## REFUSAL OF PLANNING PERMISSION

APPLICATION NO. 2019/0115

**Proposal** Erection of 1 ½ storey extension to rear of dwelling  
**At** 83 Arundell Drive, Lundwood, Barnsley, S71 5LE

**PROPOSED REAR ELEVATION**

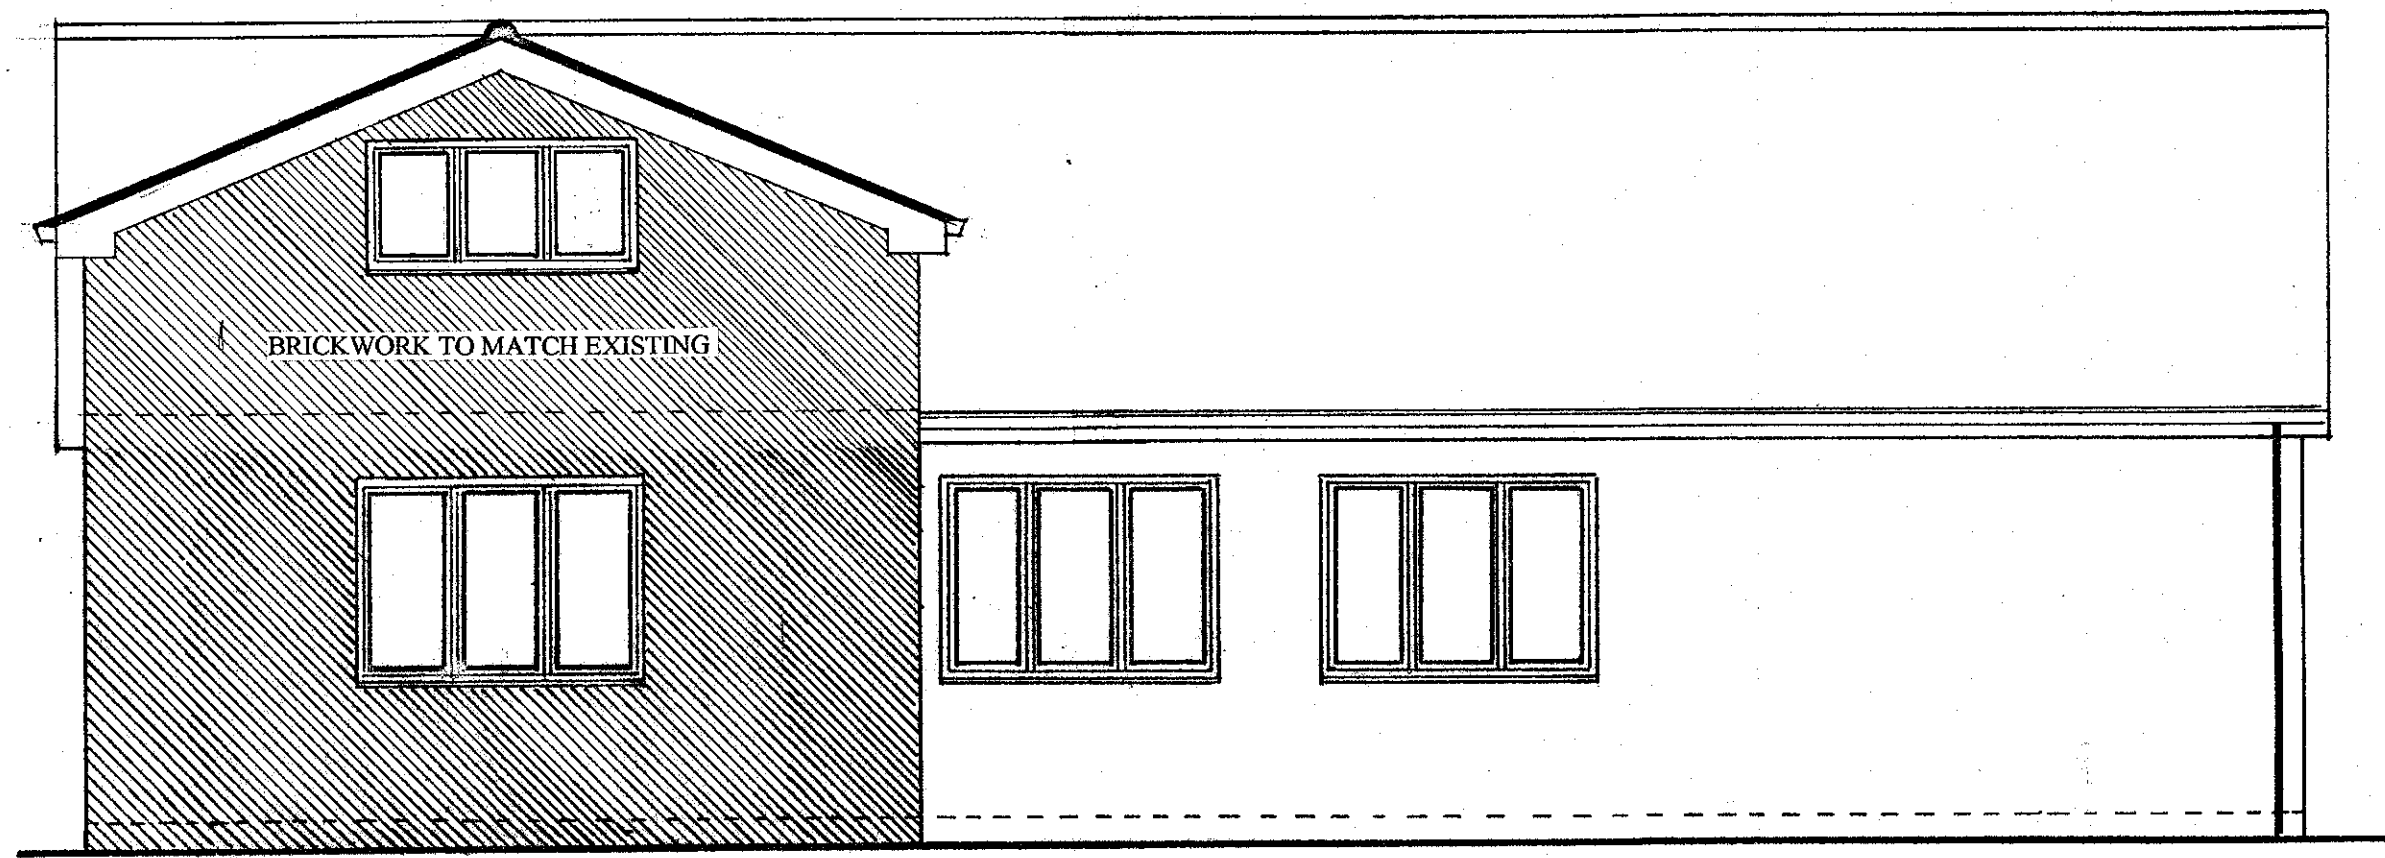
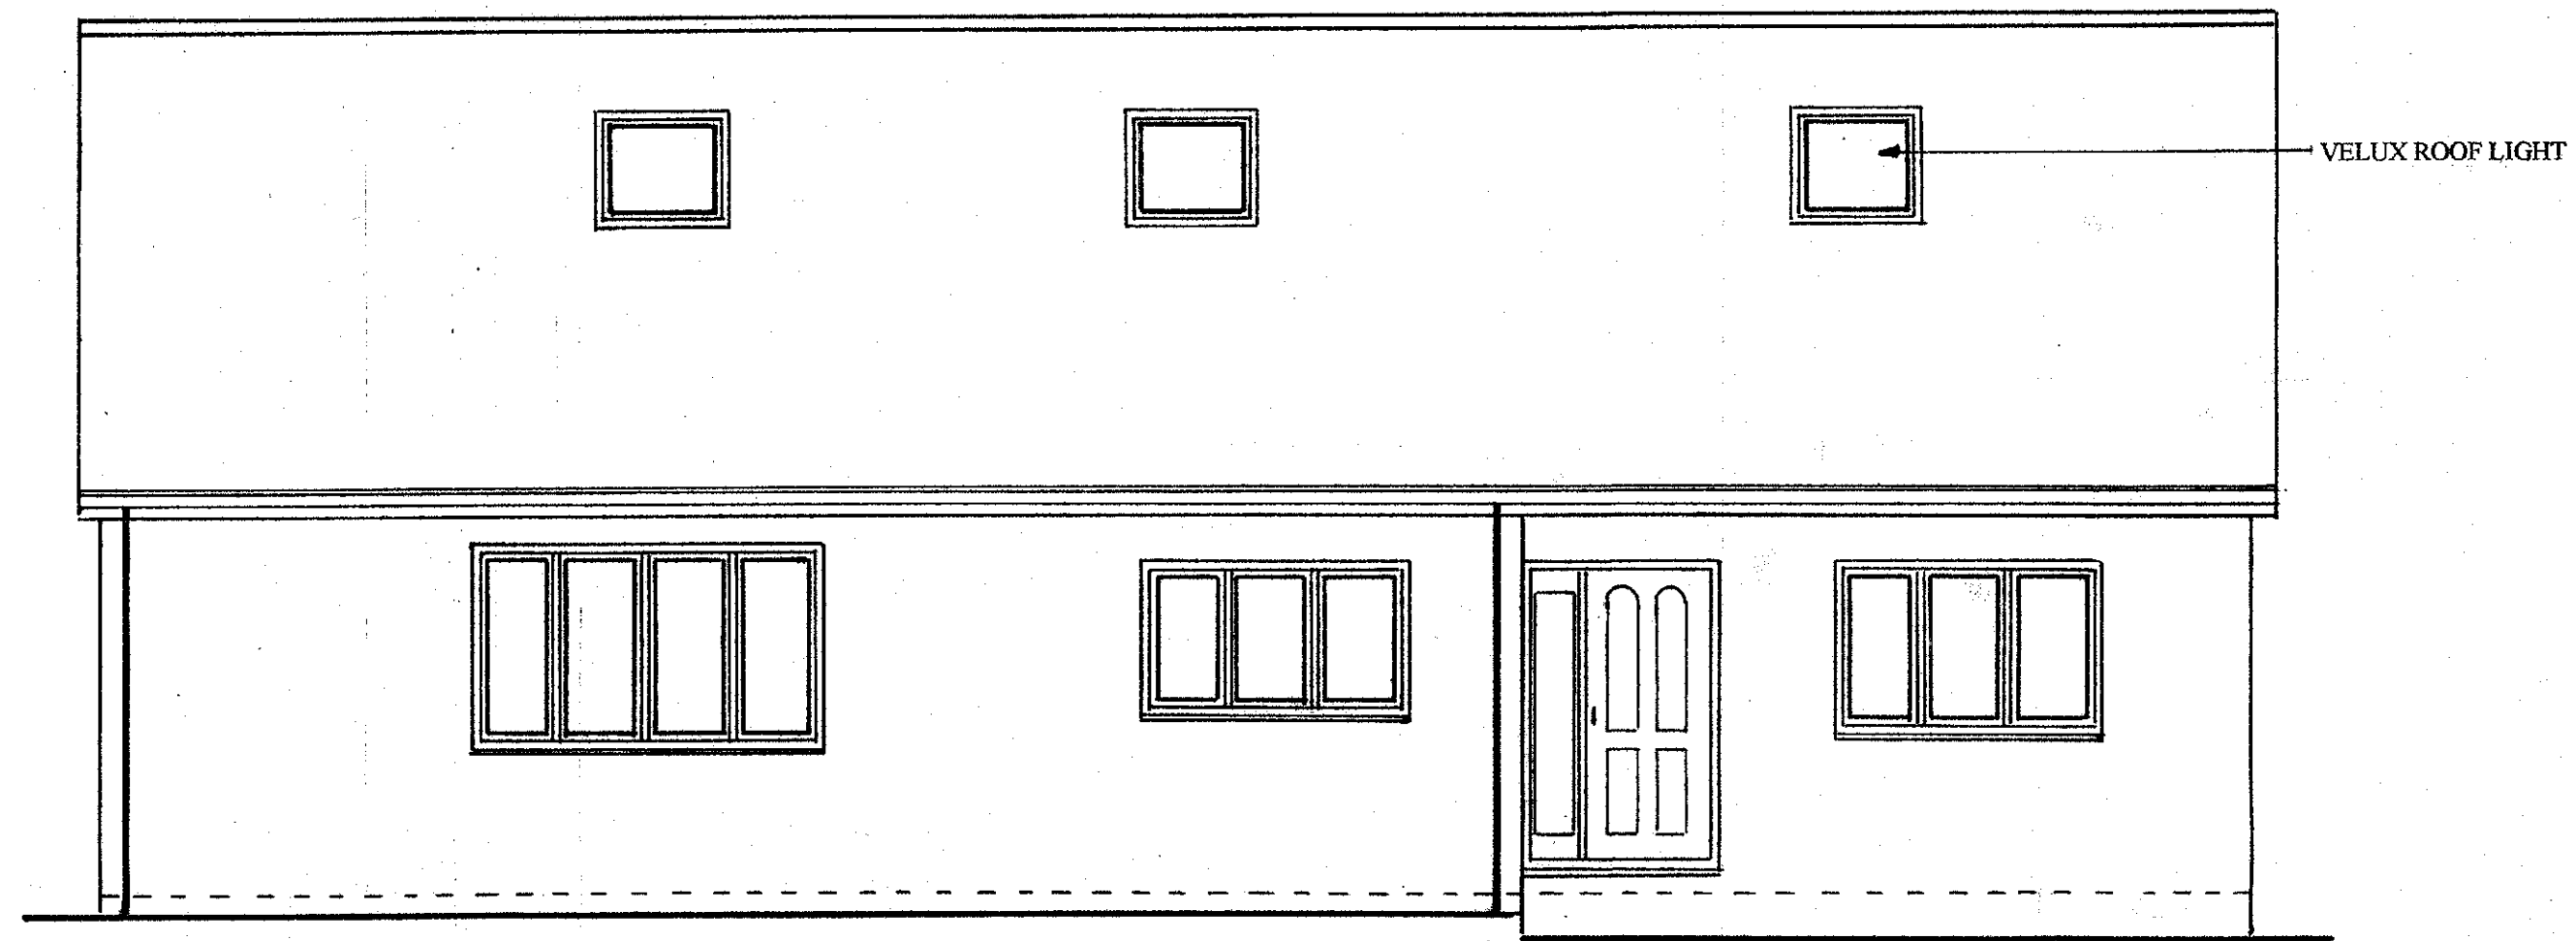
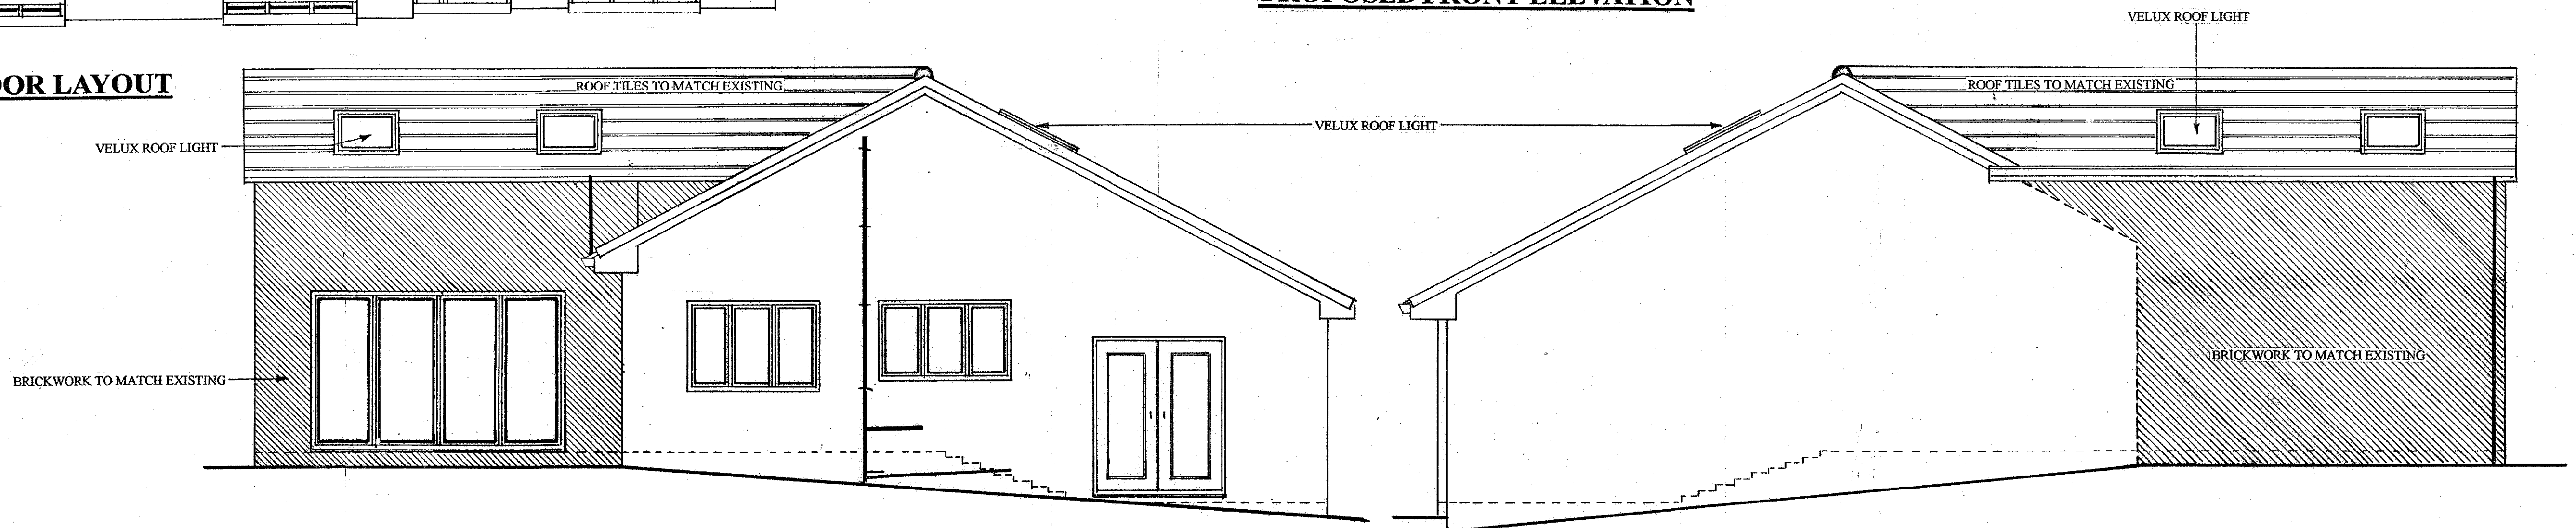
- 1 In the opinion of the Local Planning Authority the proposed extension would be contrary to Local Policy D1 of the Local Plan and the Council's Supplementary Planning Document 'House Extensions and Other Domestic Alterations' in that its design and eaves height would be architecturally inconsistent with the character of the property appearing incongruous and as a consequence would be harmful to the visual amenities of the street scene and the wider locality.
